WELWYN HATFIELD BOROUGH COUNCIL – ESTATE MANAGEMENT SCHEME
DELEGATED REPORT

APPLICATION No:	W6/2013/2246/EM
APPLICATION Site:	7 Densley Close

The proposal seeks estate management consent for the demolition of existing side extension and replacement single storey side extension, along with alterations to the roof and windows at single storey level.

Drawn By: DAMIEN	Scale: 1:100	Date: APR 2013
Drawn Status: PLANNING	Checked:	
Drawing No: 3018-P01	Revision: C

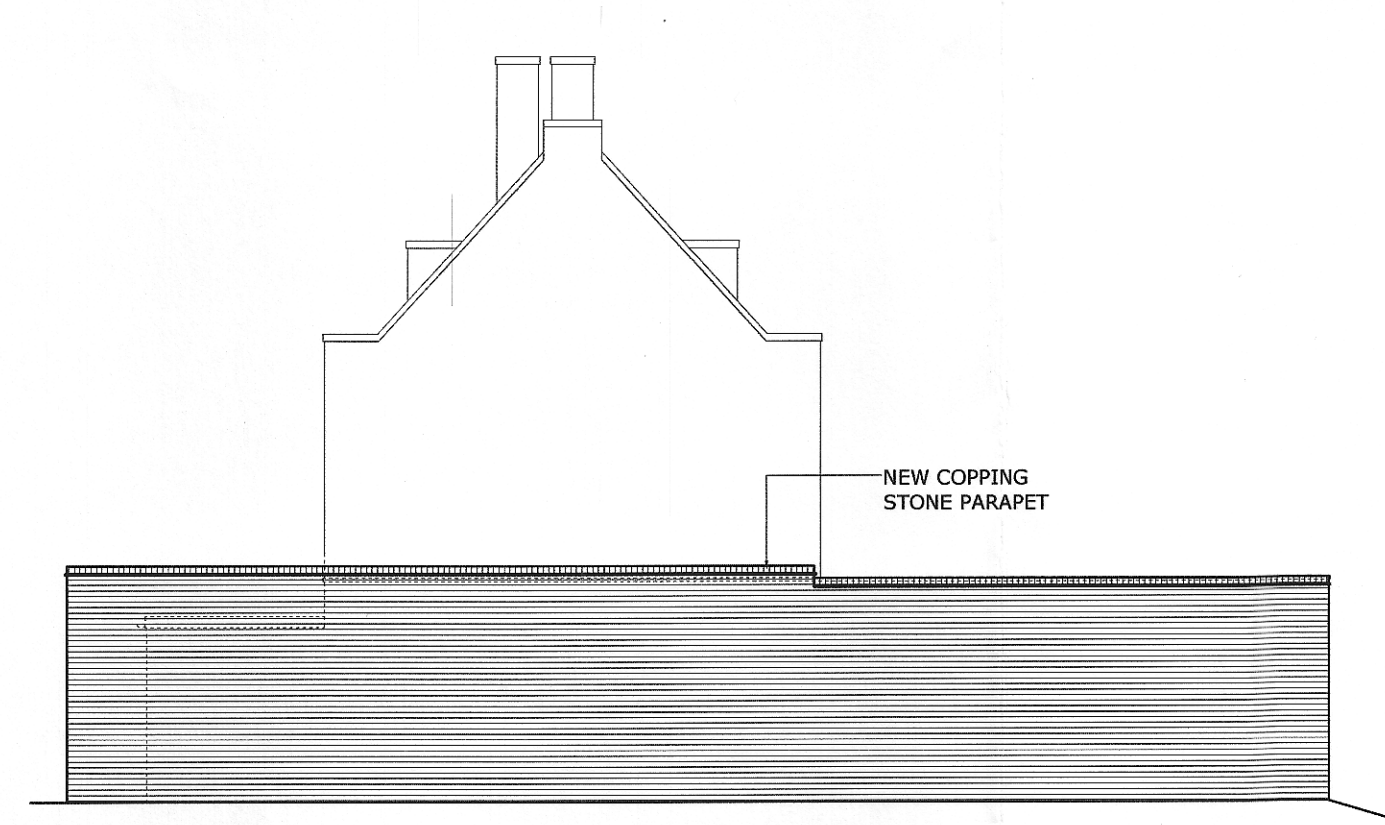
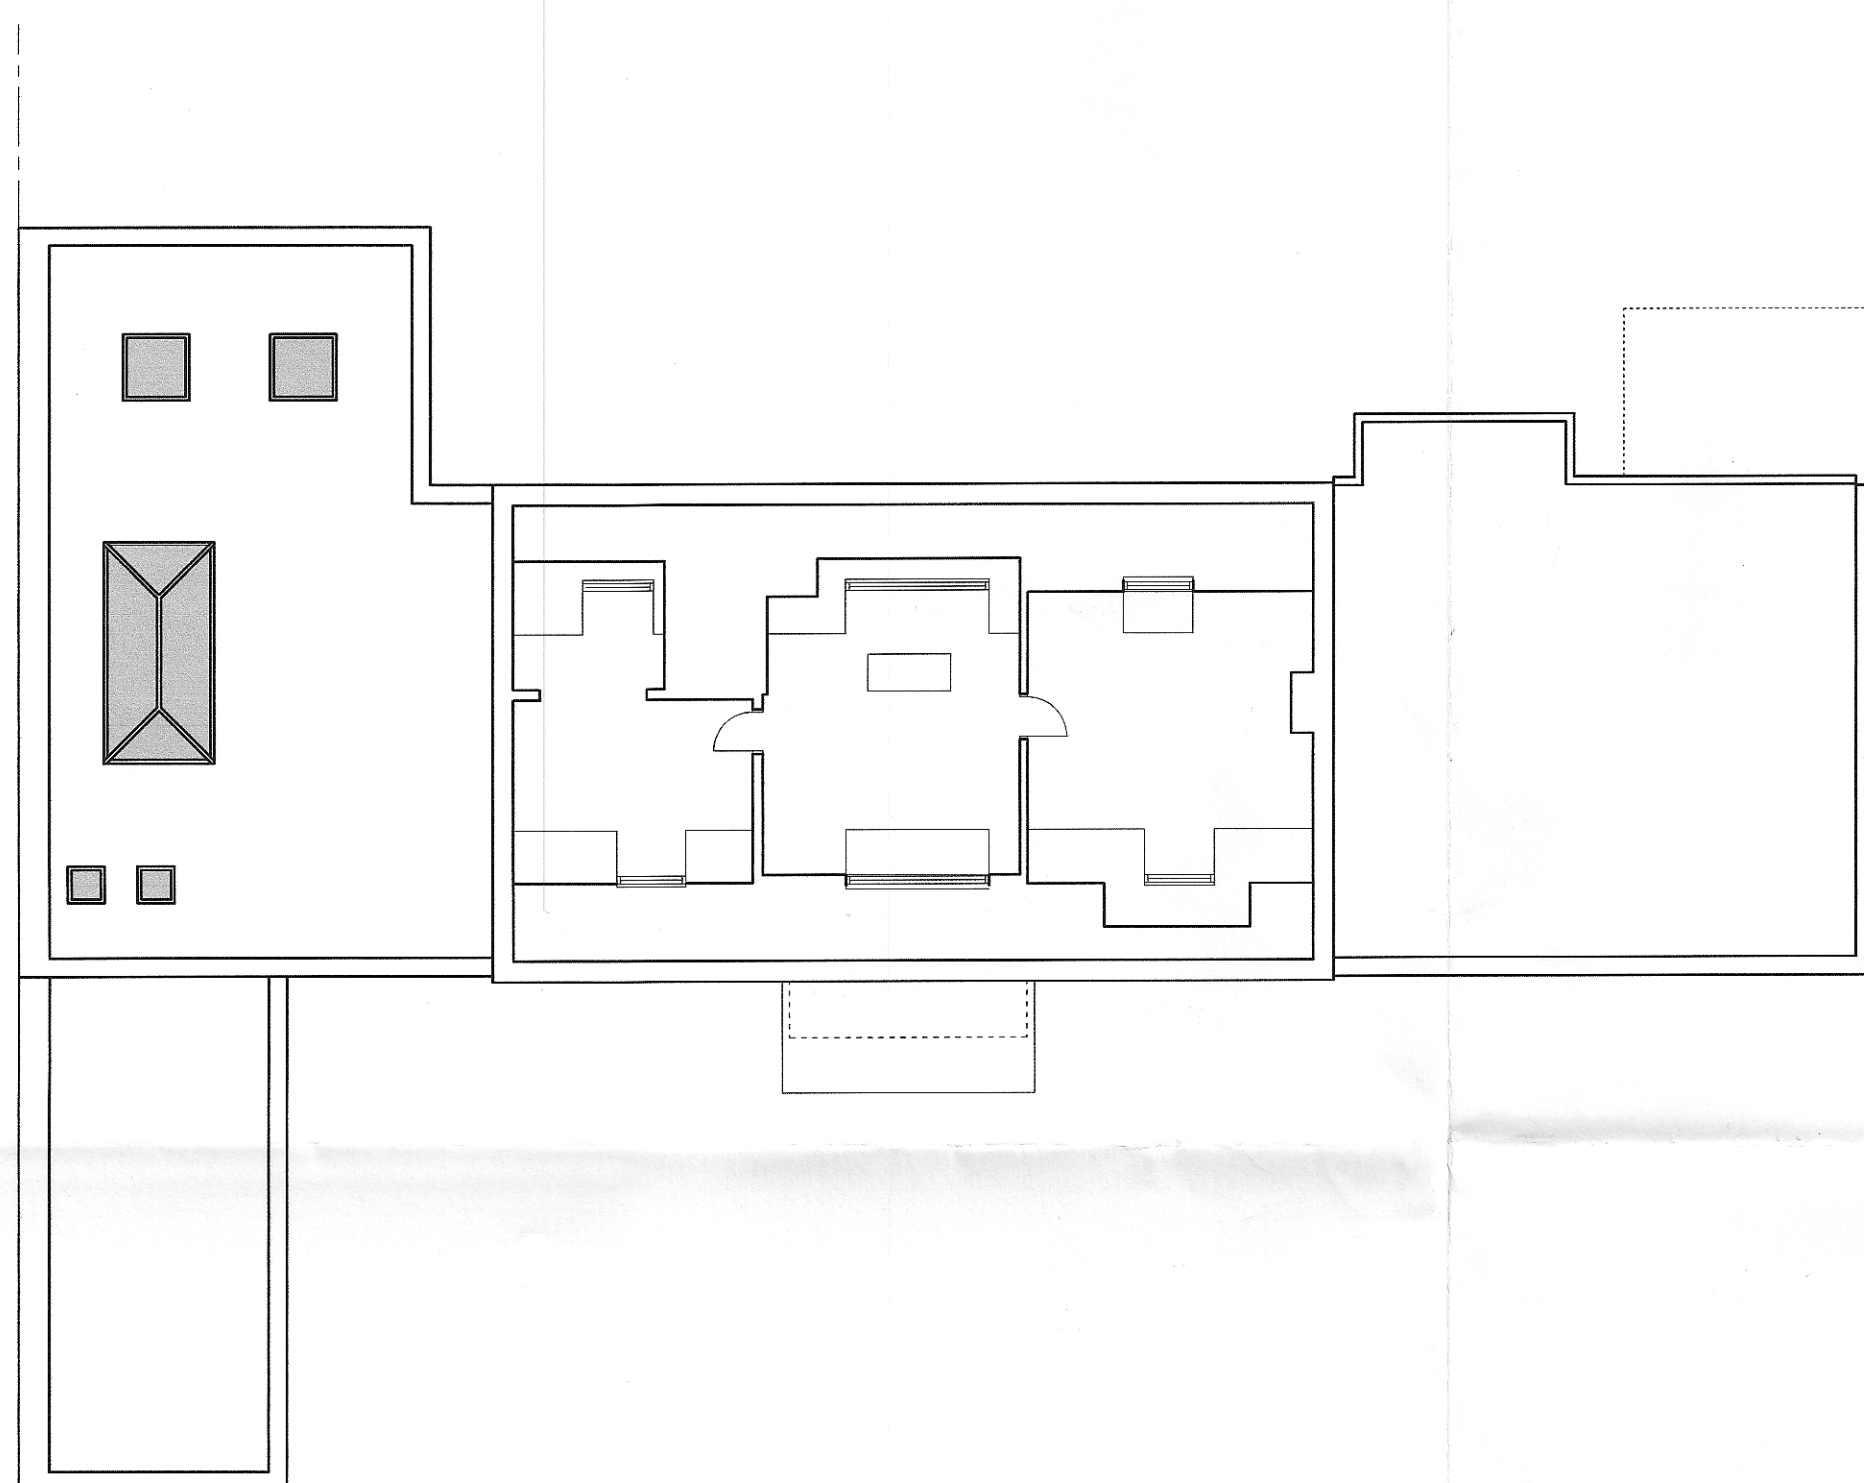
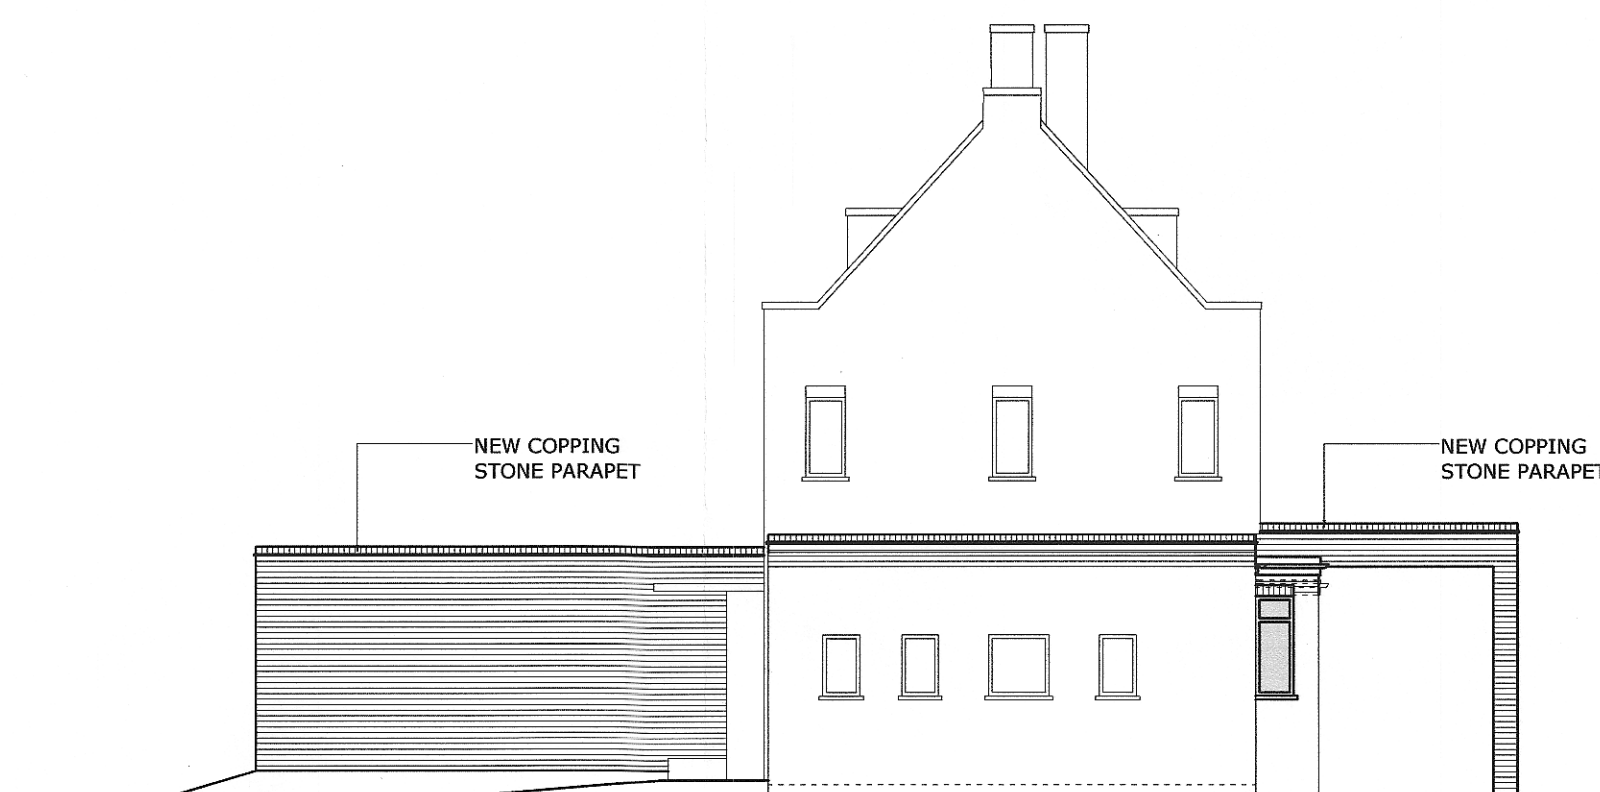
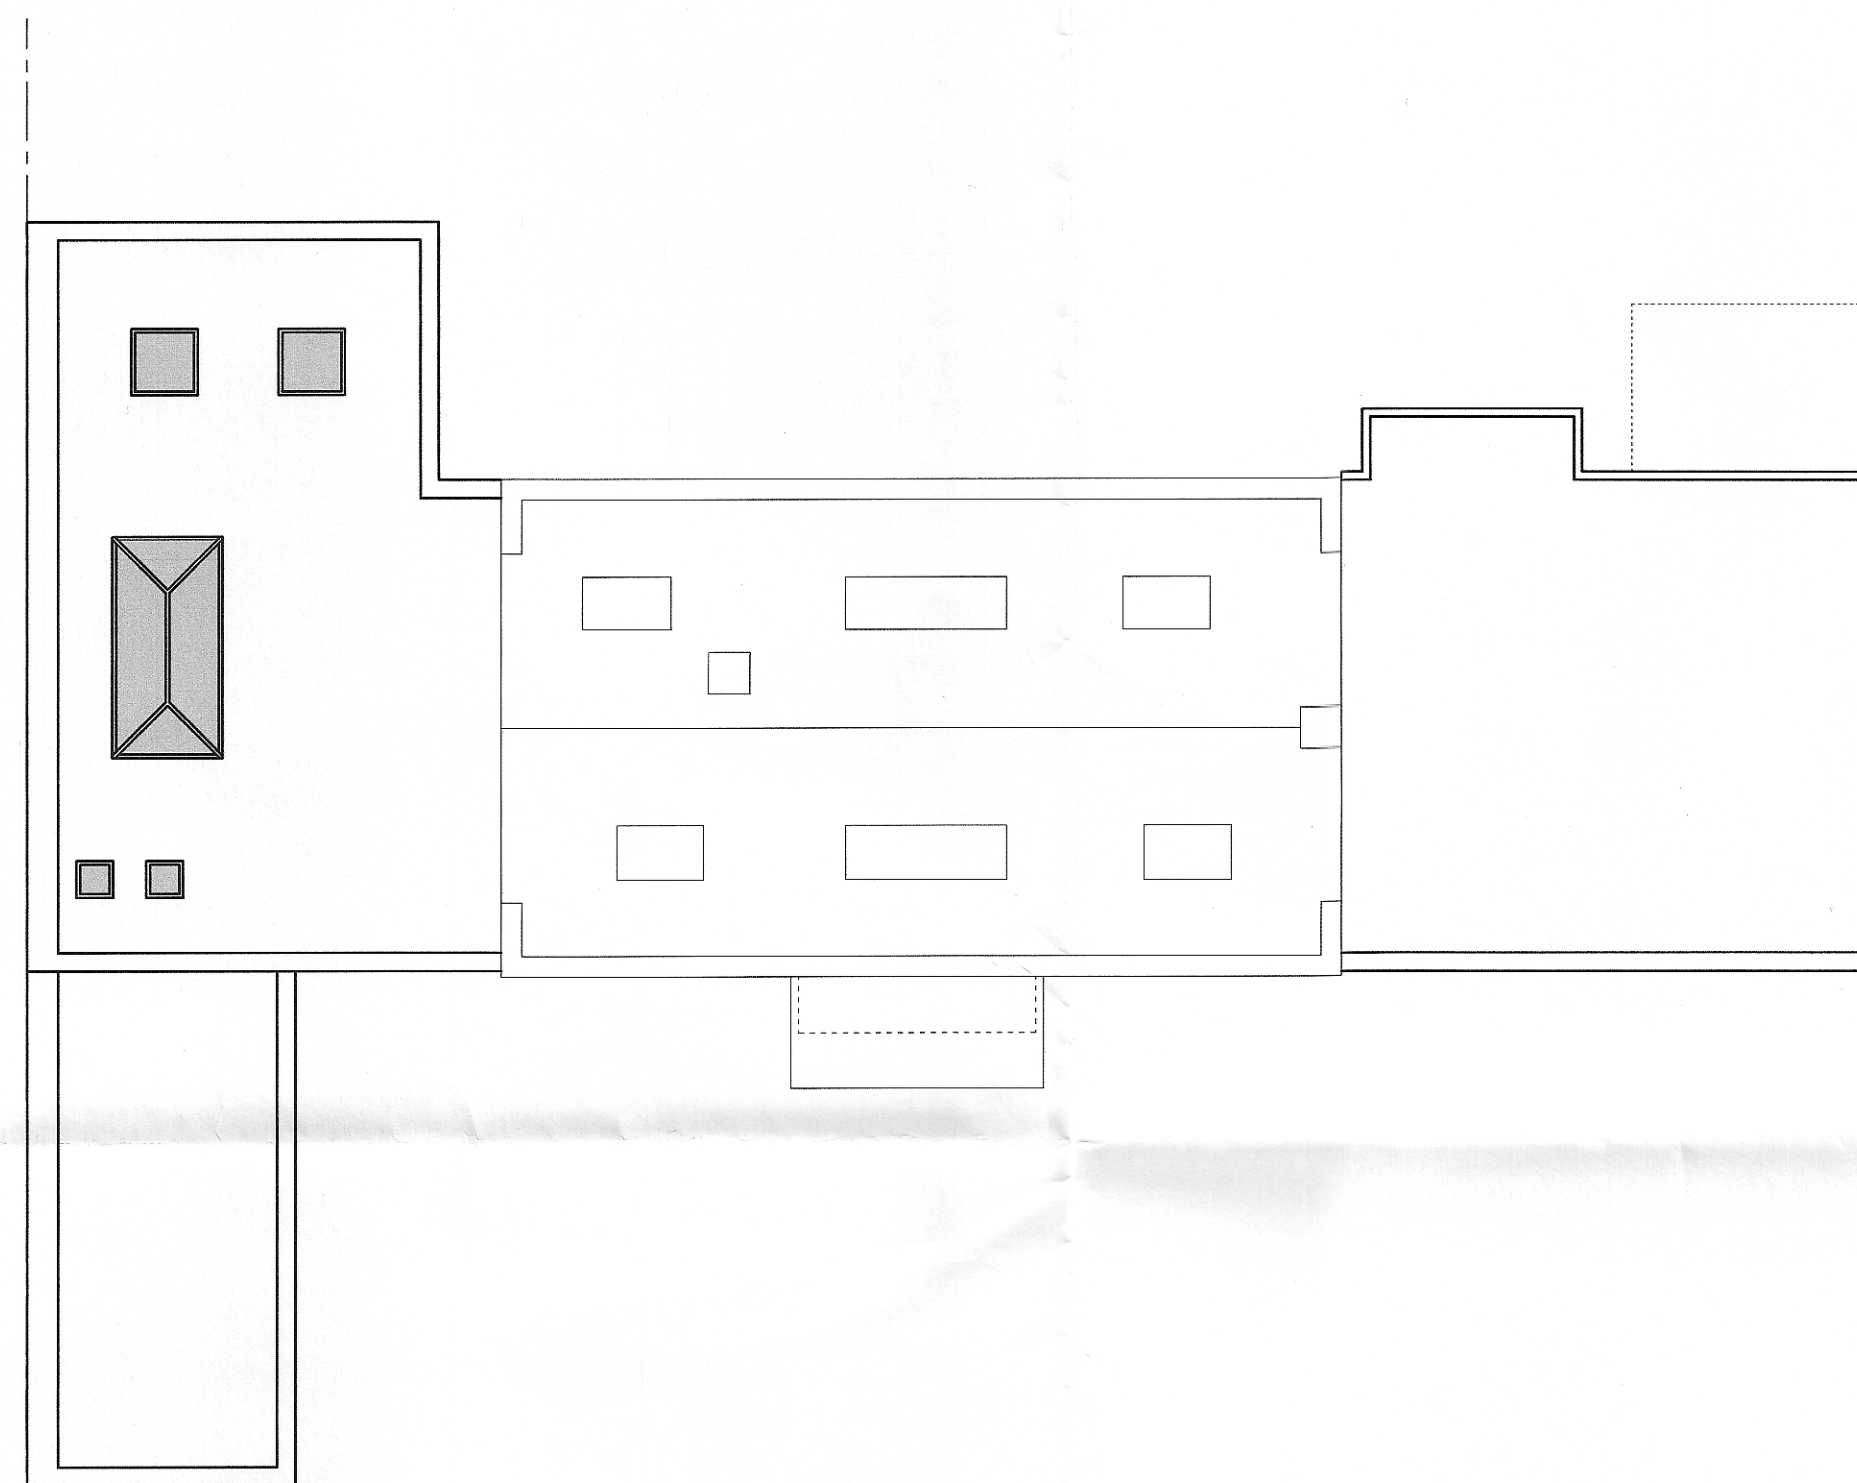
The proposal seeks to replace the existing single storey side extension along the northern elevation with a single storey side extension increasing the height of the extension to a maximum 3.25m and increasing the depth at the rear by a further 1m. Furthermore, the existing single storey extension attached to the southern elevation will increase in height by a further 0.2m. The proposal differs from that previously refused under estate management application, ref: W6/2013/1279/EM, by virtue of the northern elevation extension being reduced in height by 0.35m and the southern elevation extension being reduced in height by approximately 0.35m. The proposal was refused by virtue of the height of the parapet wall being near to the height of the first floor window sills which would appear stark and over dominant within the streetscene.

It is considered that the proposal has been sufficiently reduced in height to reduce the overall bulk and would more in keeping with the height of the parapet walls which exist within the streetscene. Furthermore, the proposal would incorporate coping stone as the parapet finish. The rooflights proposed on the northern side extension will not be visible within the streetscene and has been confirmed through an email from the agent, dated 10 December 2013. It would also be appropriate for condition the application for samples of materials to be submitted prior to commencement of development to ensure the materials appropriately match the existing dwellinghouse.

The properties most impacted by the proposal are neighbouring properties, No. 5 Densley Close to the north and No.19 Scholars Mews to the south. The existing garage is attached to the neighbouring single storey side extension at No.5 Densley Close. The existing garage already extends further beyond the rear of No.5 by approximately 1m with the proposed replacement side extension resulting in approximately 2m extension beyond the rear of No.5. Windows exist on the rear of No.5 in close proximity to the proposed extension however a 2m extension is not considered to result in an unduly dominant feature when viewed from these windows. Furthermore, the proposal is not considered to detrimentally impact upon loss of sunlight/daylight skylight when compared to the existing extension taking into consideration the extension will only extend a further 1m in depth and the orientation of No.5 to the north east of the application dwelling where a limited amount of light reaches these windows during large parts of the day.

The proposed height increase of 0.2m to the existing single storey side extension extending beyond the southern elevation is considered sufficient distance from No.19 Scholars Mews (approximately 10m) not to detrimentally impact upon loss of sunlight/daylight. The existing side windows are being retained with the floor level increase internally of approximately 15cm. However, the existing window openings and siting are not being altered and therefore the proposal is not considered to result in any further overlooking/loss of privacy to neighbouring properties when compared with the existing situation.

6. The development/works shall not be started and completed other than in accordance with the approved plans and details: 3018-OS1 & 3081-OS2 Rev A received and dated 24 October 2013 & 3018-P01 Rev C received and dated 11 December 2013
